Date: 19 October 2021
Our ref: Case: 14030 Consultation: 371281
Your ref: EN010095

Boston Alternative Energy Facility (BAEF)

The following constitutes Natural England's formal statutory response for Examination Deadline 1.

DRAWING No.	PB6934-RHD-01-ZZ-DR-3004	SUITABILITY	S0	REVISION	0
-------------	--------------------------	-------------	----	----------	---

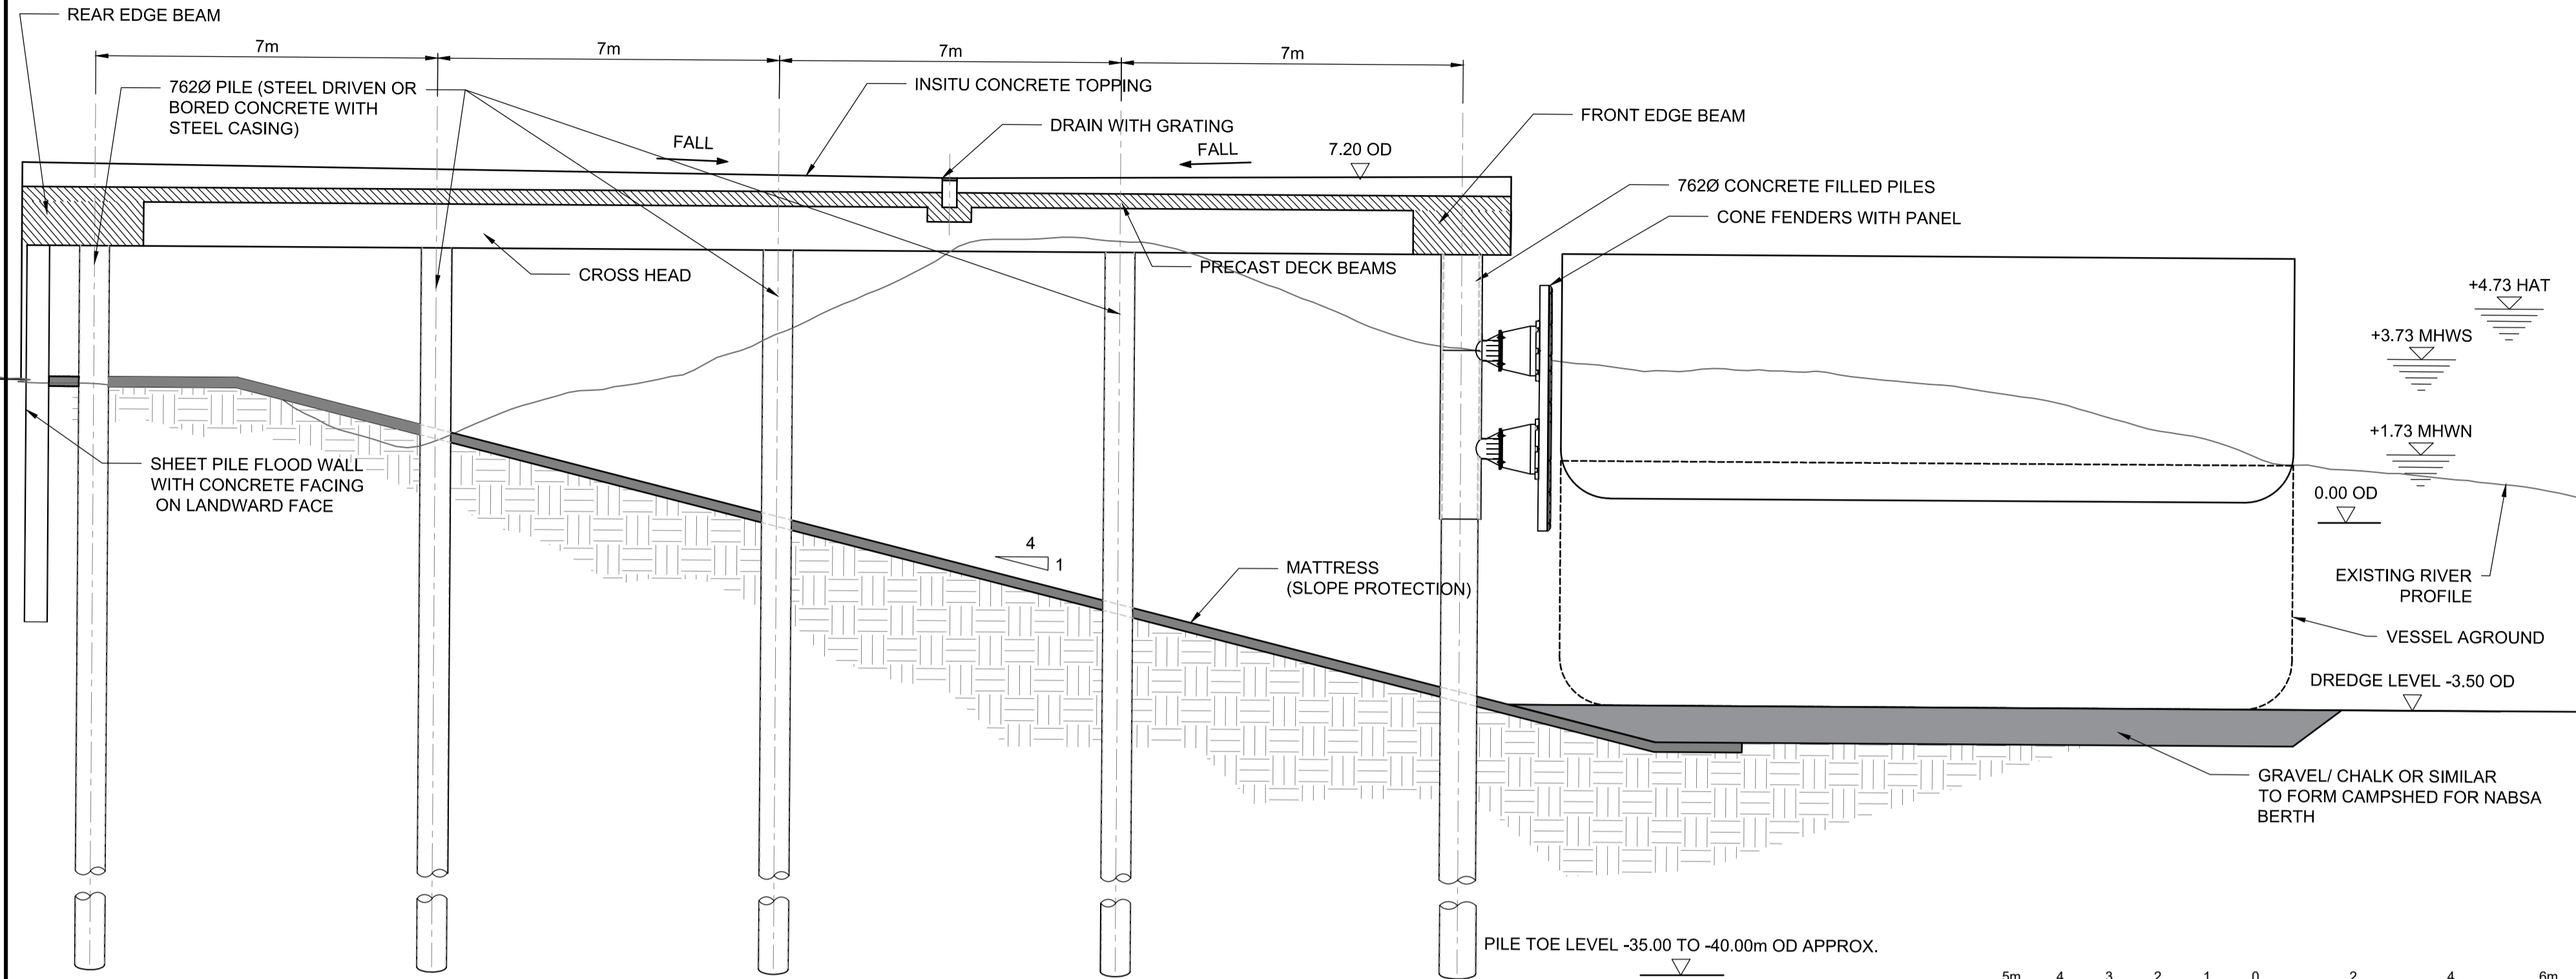
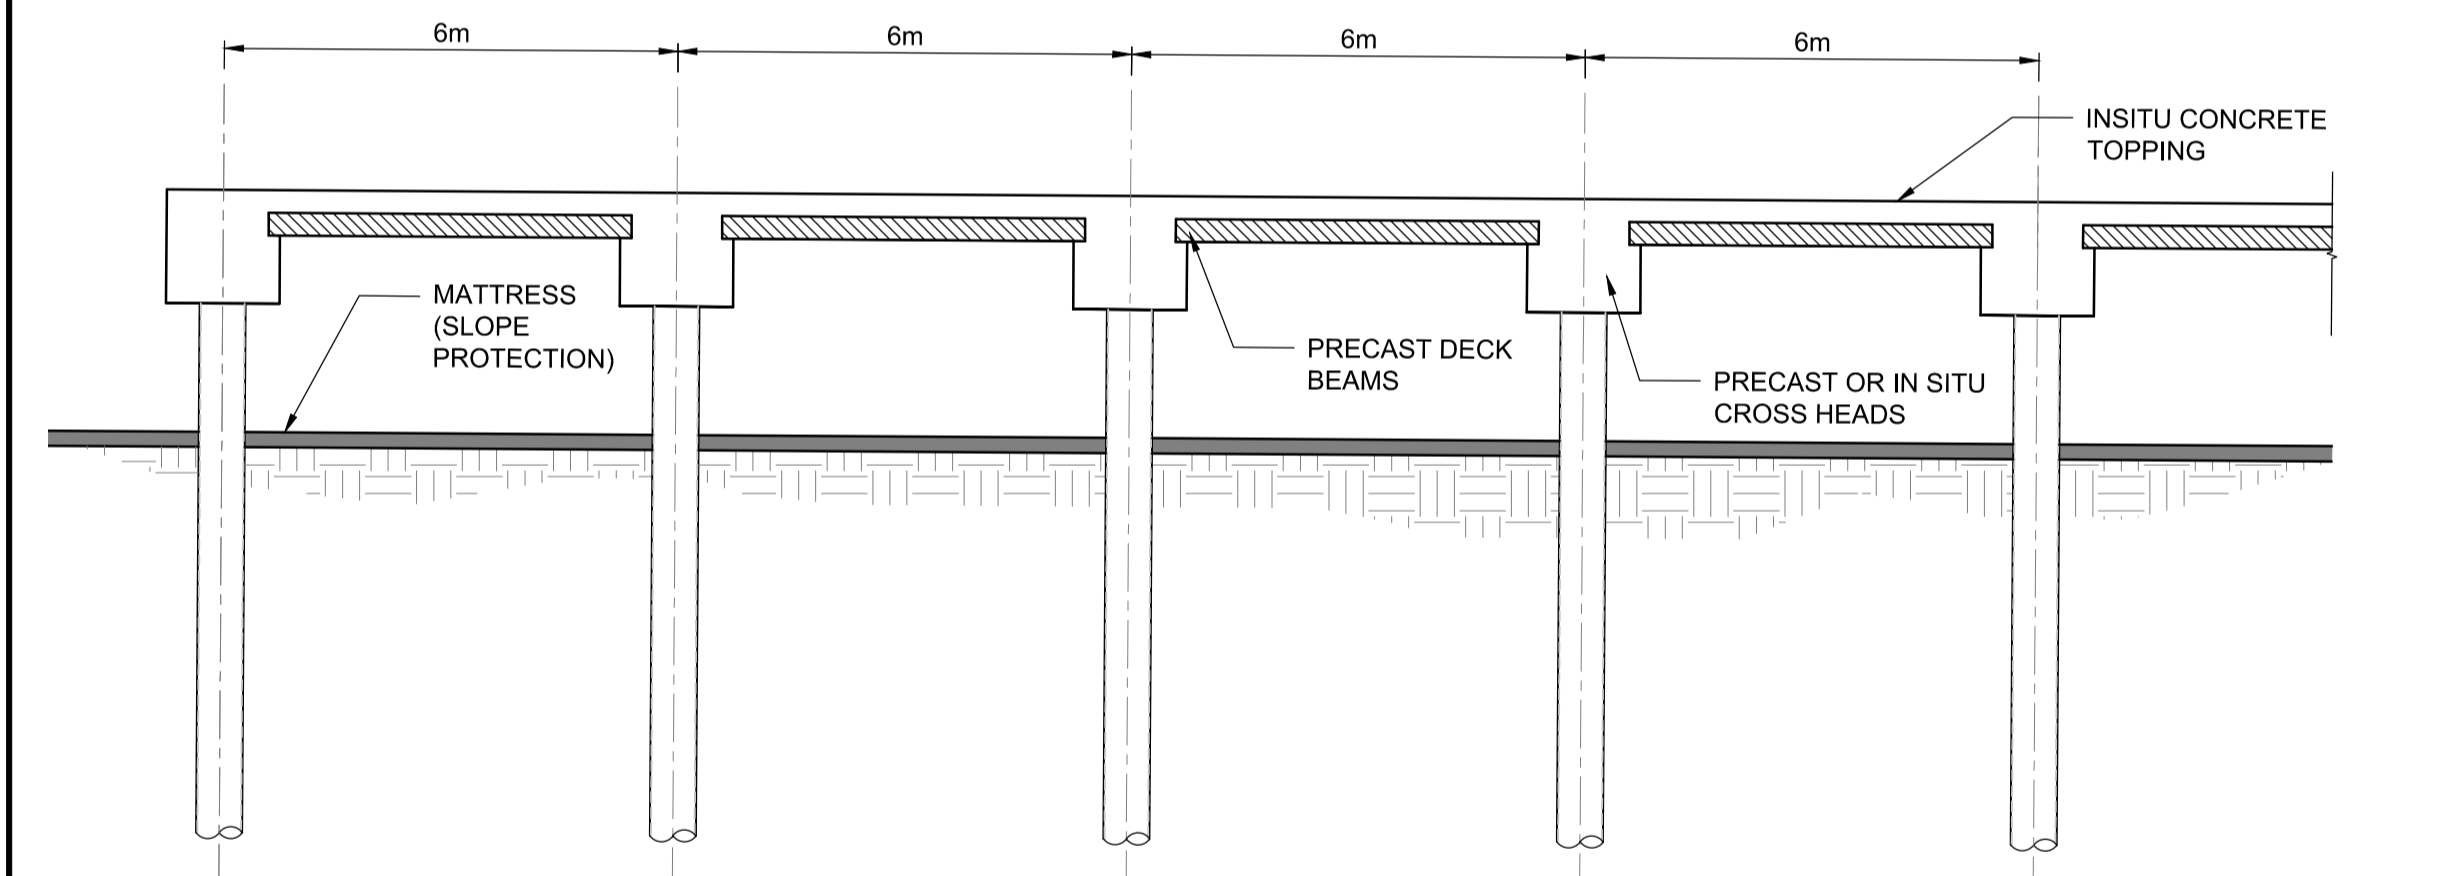
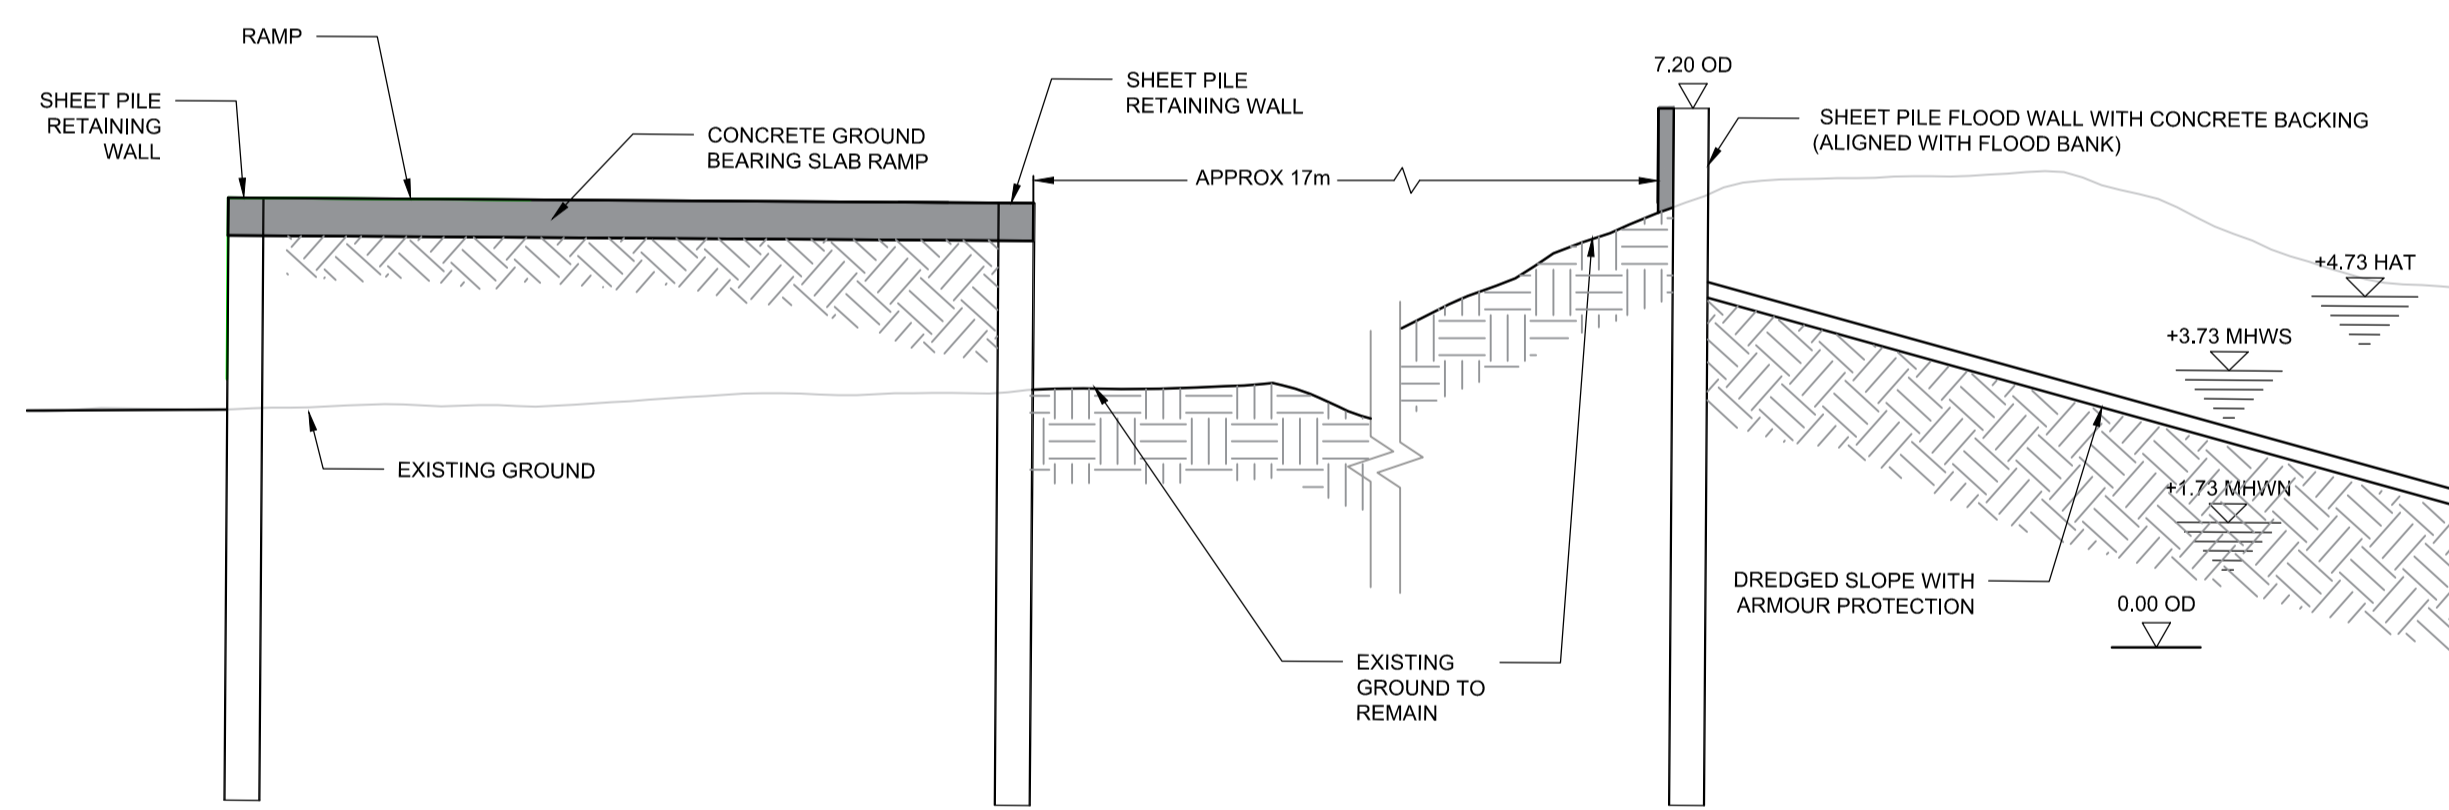
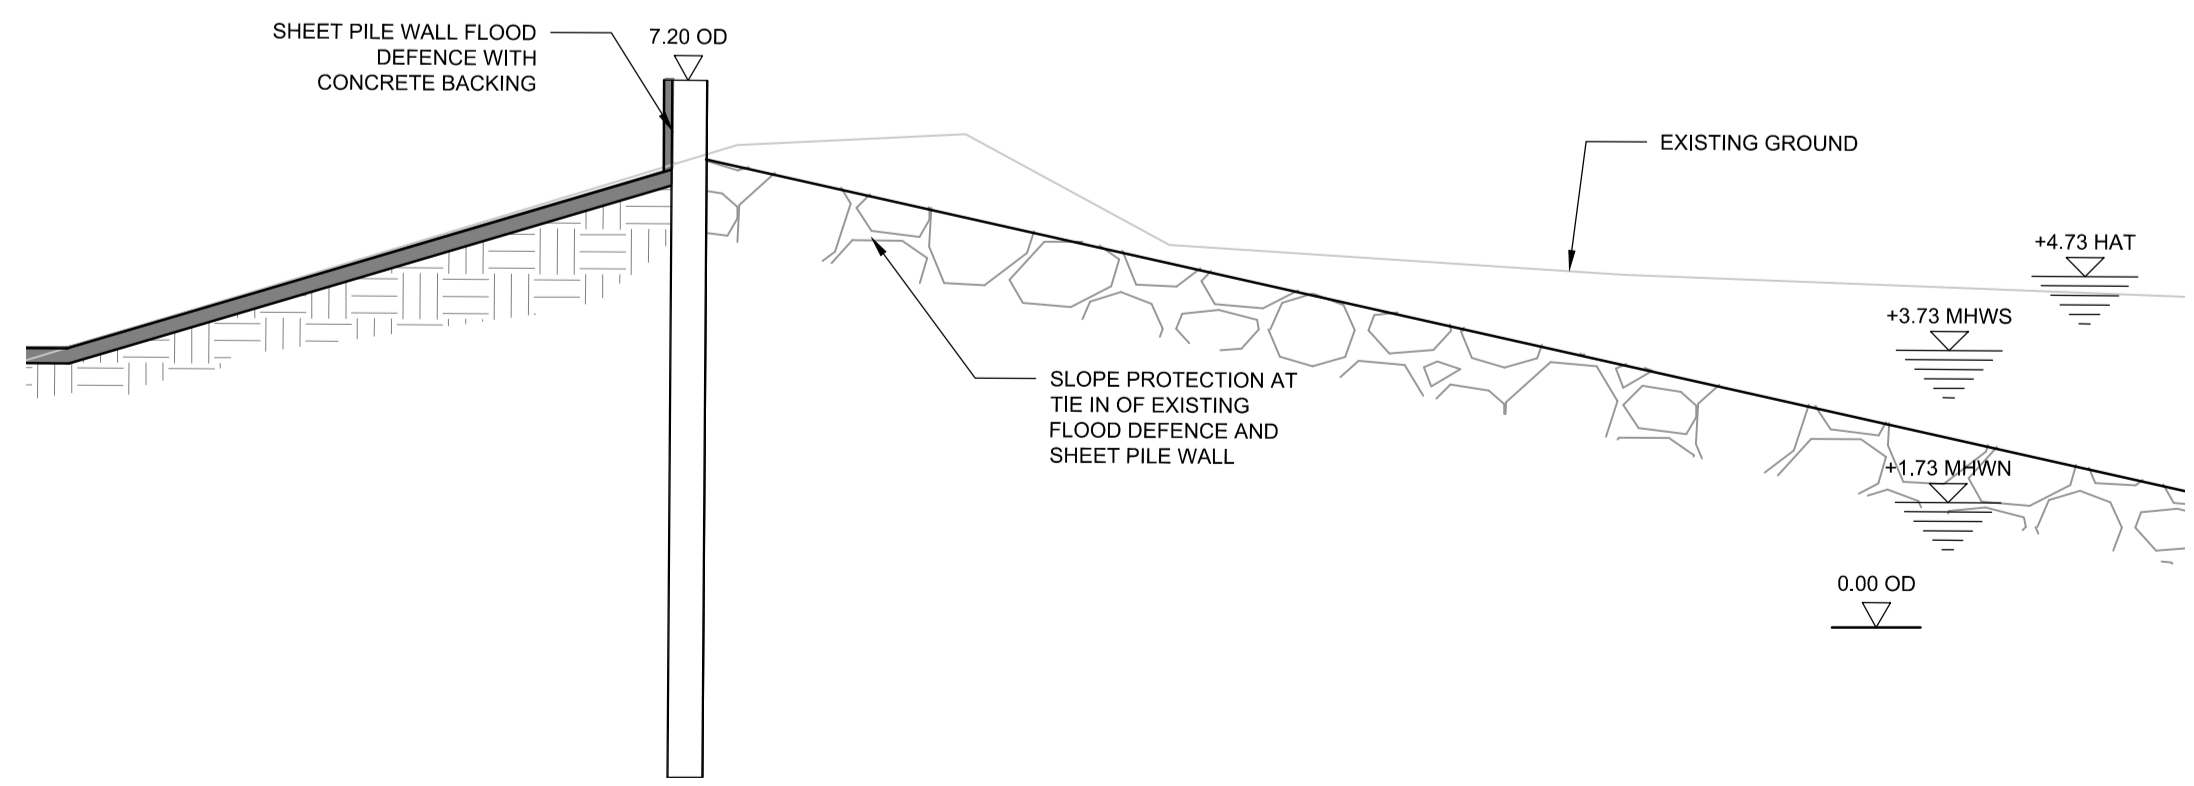
3	<p>Natural England requests details on slope protection extending over 10,000m²? Fig 5.2 sheet 3 shows concrete facing on the mattress protection under wharf and possibly big rocks (no key) for slope protection. Natural England is concerned about the potential scouring of the Habitat Mitigation Area and also to the north, and on opposite bank.</p>		<p>On 13th August the Applicant informed NE that the effects of indirect impacts would be negligible (increase in tidal prism at the wharf is less than 2% of the tidal prism on the entire Haven). Natural England doesn't believe 2% change in the tidal prism is insignificant and therefore awaits further assessment to demonstrate that the impacts would be negligible.</p>
